Our reference: ECM: 8312191
Contact: Kathryn Sprang
Telephone: 4732 7834

9 August 2018

Re: Altis Warehouse and Logistics Hub at 585-649 Mamre Road Orchards Hills (SSD 7171)

LONGITUDINAL SECTION - CL NORTHERN CHANNEL  
HORIZONTAL SCALE 1:500  
VERTICAL SCALE 1:100

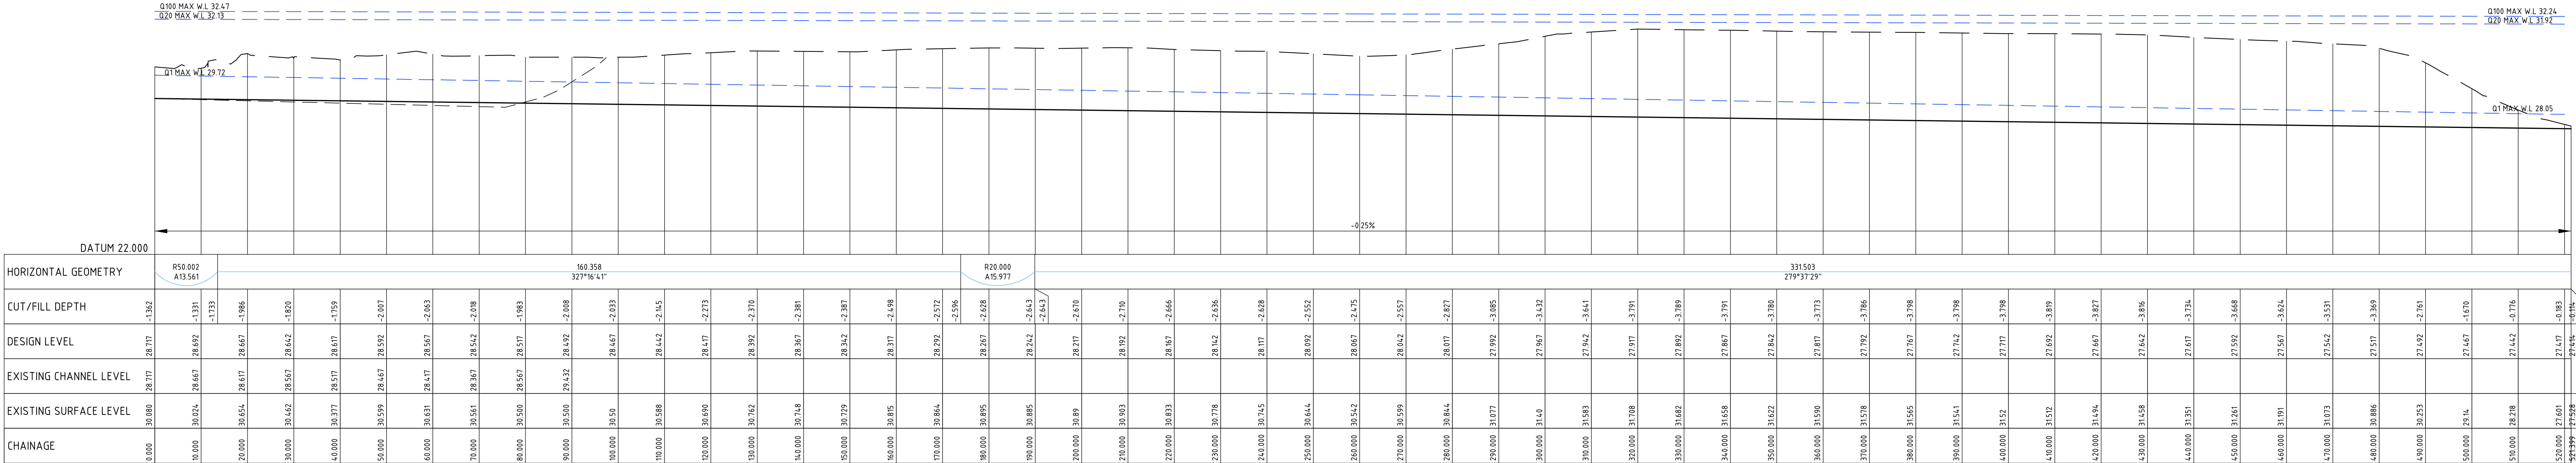
In addition to the above the extent and level of the 1% AEP local overland flows (pre and post) shall be shown on the site plan and all cross-sections.

NOTE: ALL DIMENSIONS SHOWN
HEREON ARE APPROXIMATE
& SUBJECT TO FINAL SURVEY

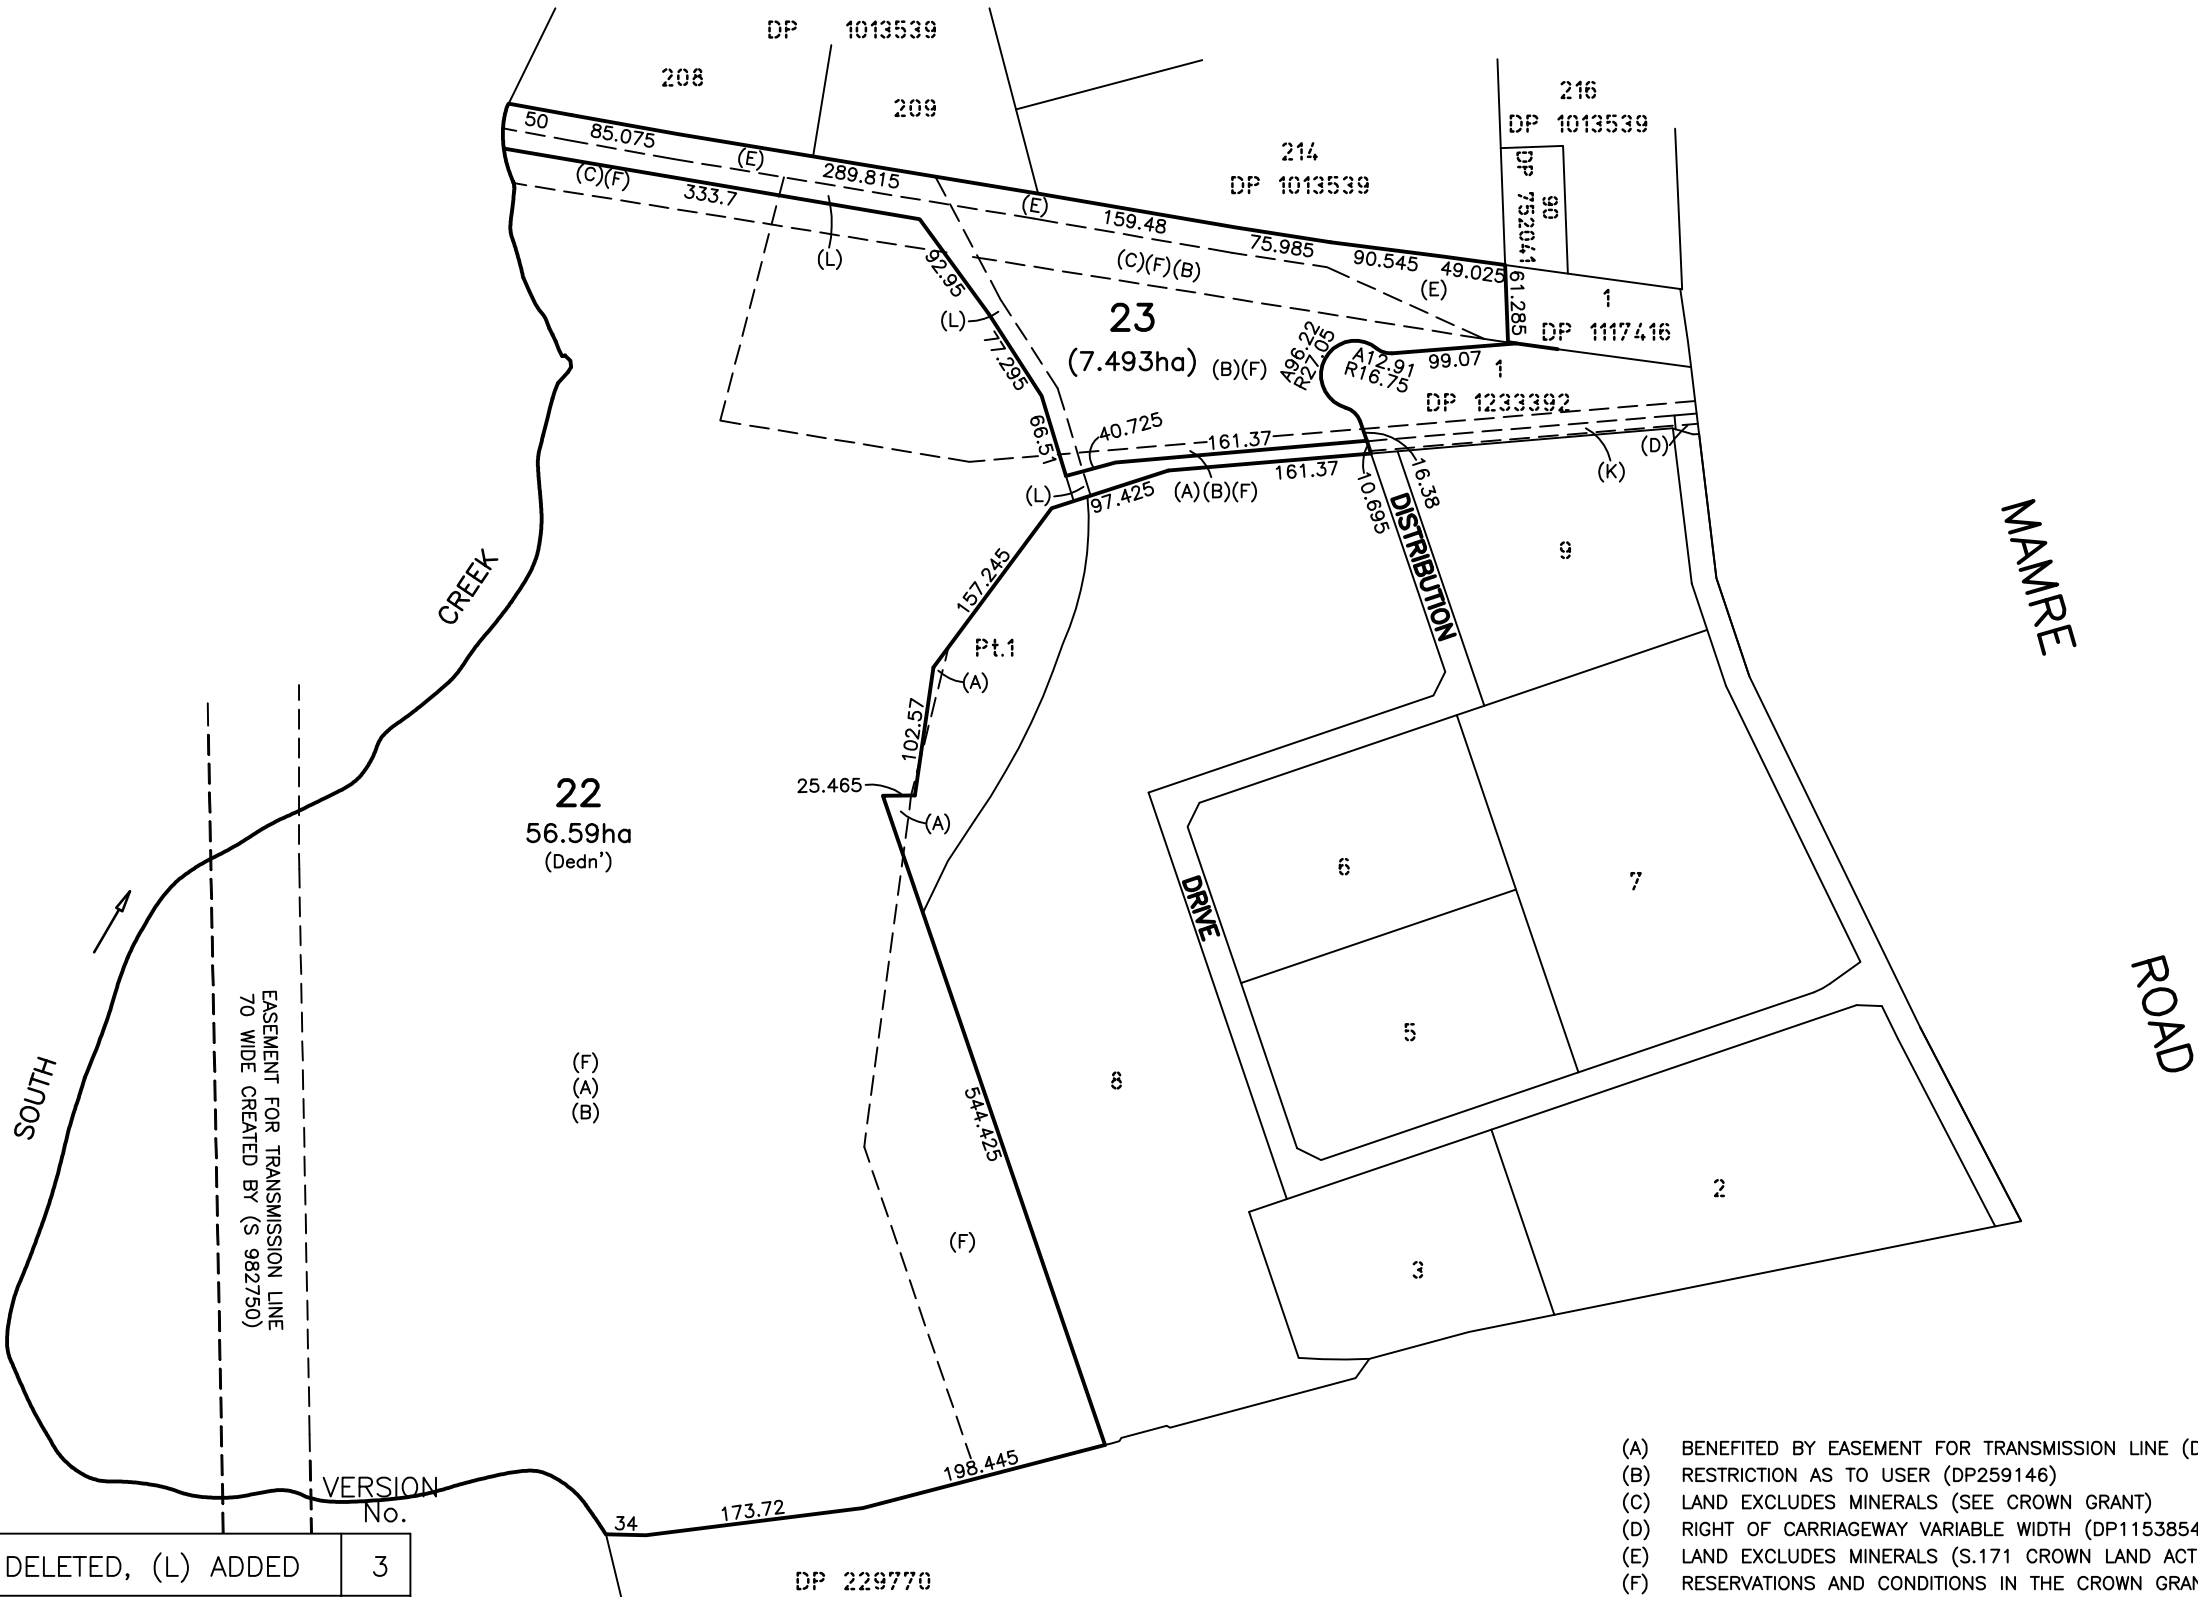
- Easement width shall be 1 metre plus top width of the 1% AEP design flow with 500mm freeboard;
- The subdivision plan shows '(L) proposed easement to drain Water 14 & 35 Wide'. This shall be amended to state – 'Proposed Easement to Drain Water 14, 35 Wide & Variable'.

- The subdivision plan shall show the existing drainage easement (G) on the plan to be deleted;
